Falcon Fire #3 Approval of Location, U-20-1

Please accept the following comments from El Paso County Public Health for the project referenced above:

NEW STATION SITE PLAN  
FALCON, COLORADO

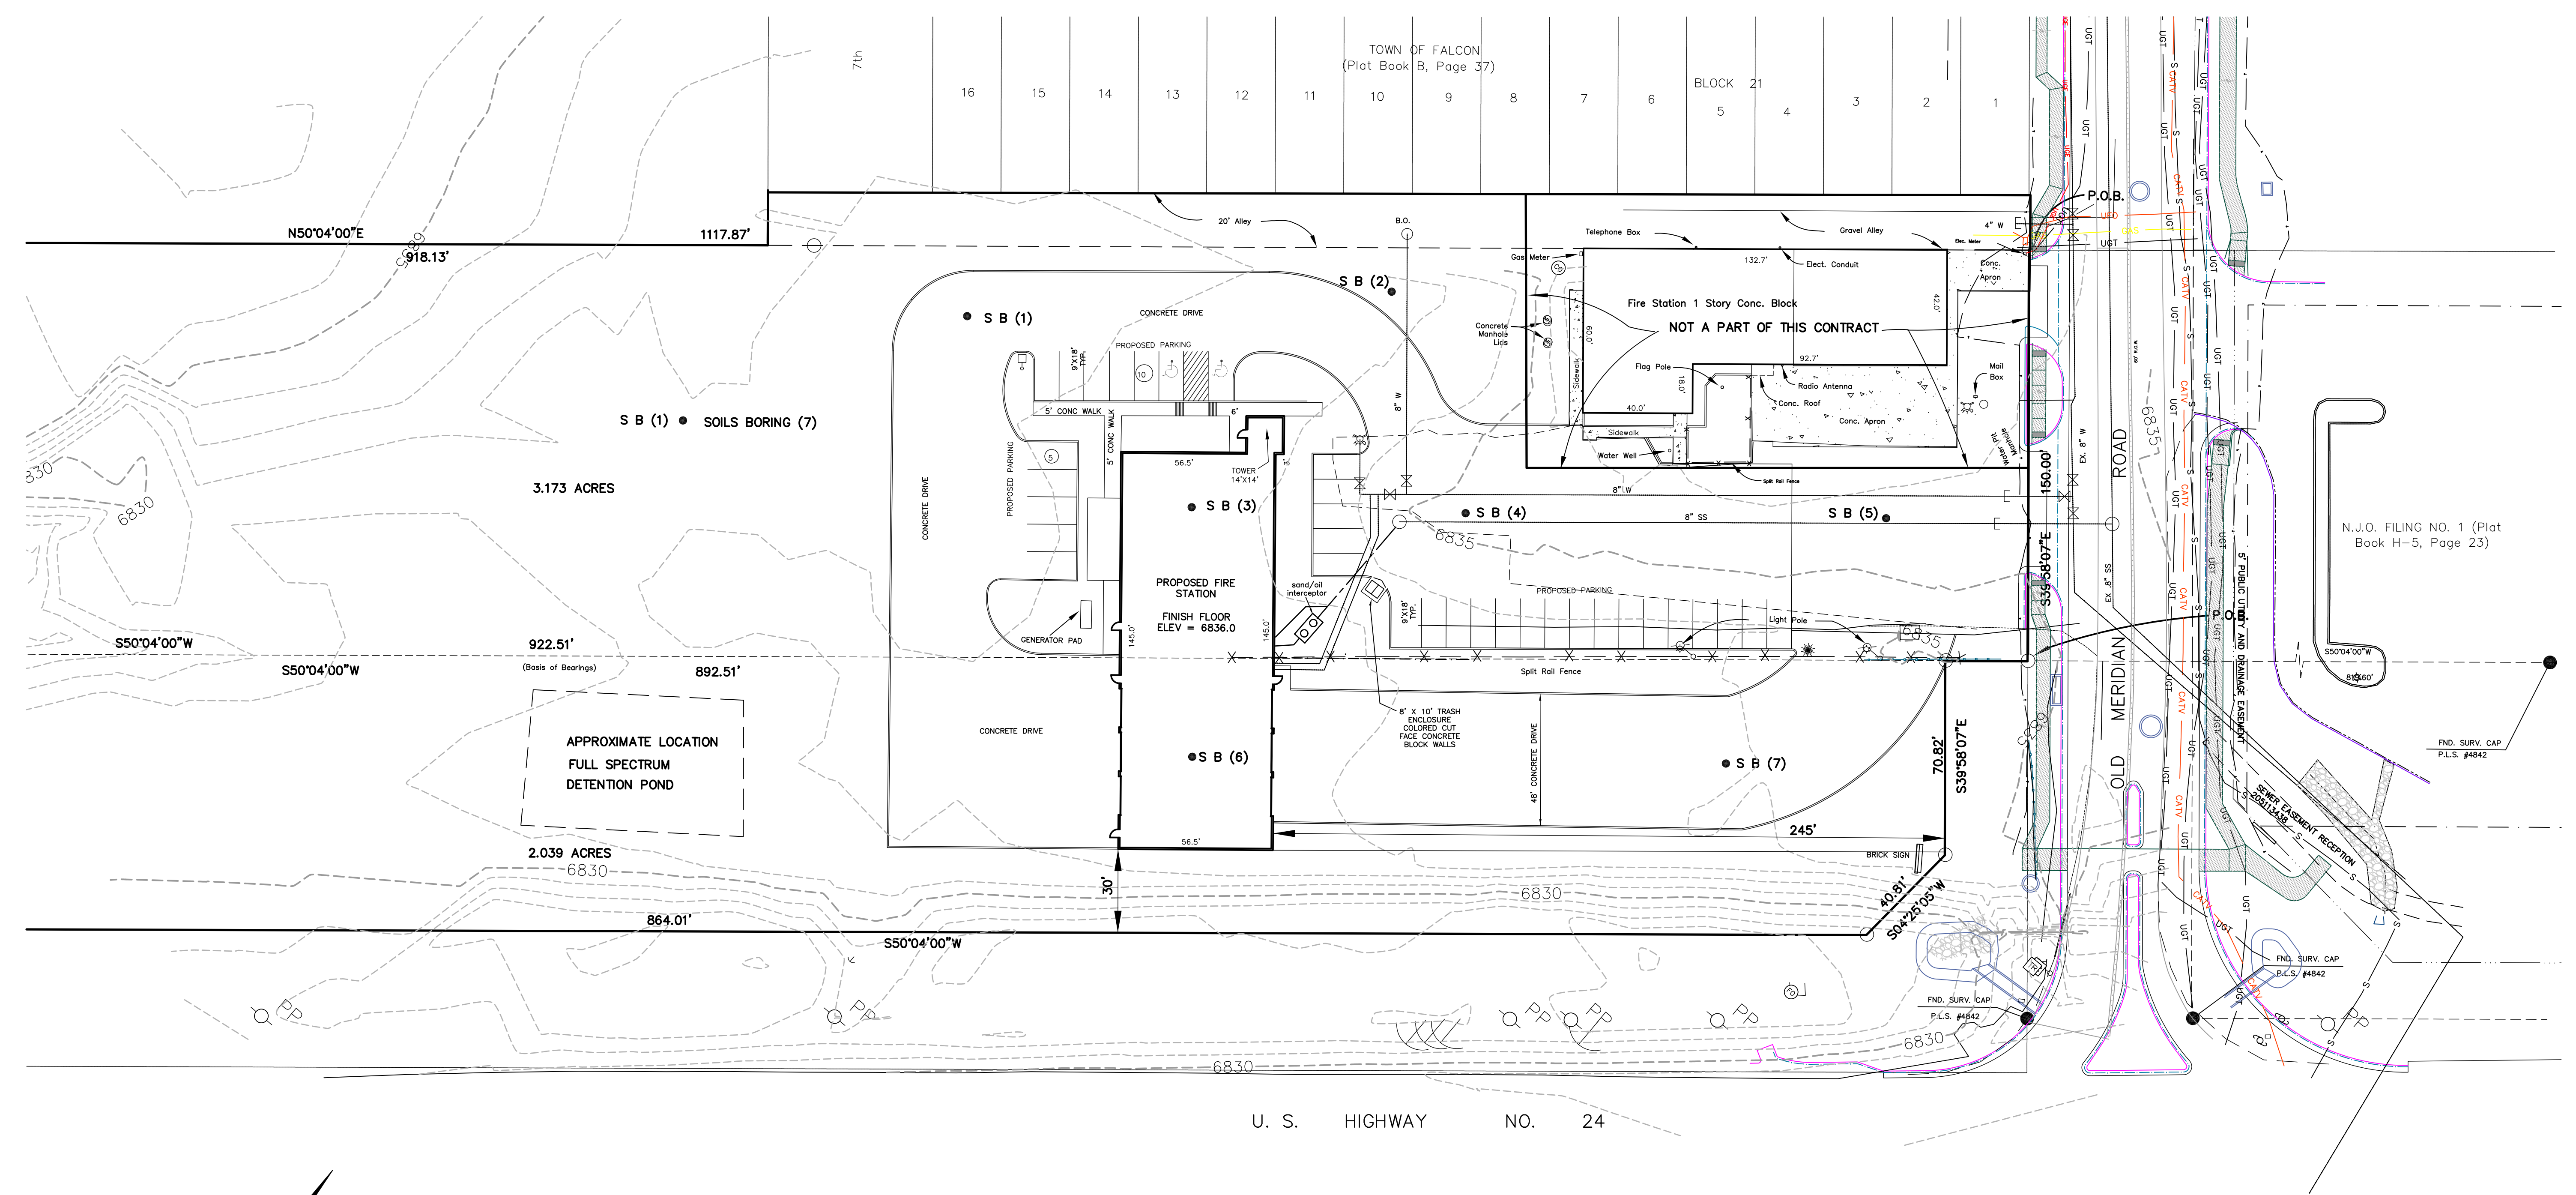
- **The Fire Station #3 is currently served water by a well and wastewater by an onsite wastewater treatment system (OWTS). El Paso County Public Health (EPCPH) has no issues with the abandonment of the existing water and wastewater services and connecting to Falcon Highlands Metropolitan District.**

- **The water quality basins must have mosquito control responsibilities included as a part of the construction design and maintenance plan to help control mosquito breeding habitat and minimize the potential for West Nile Virus.**
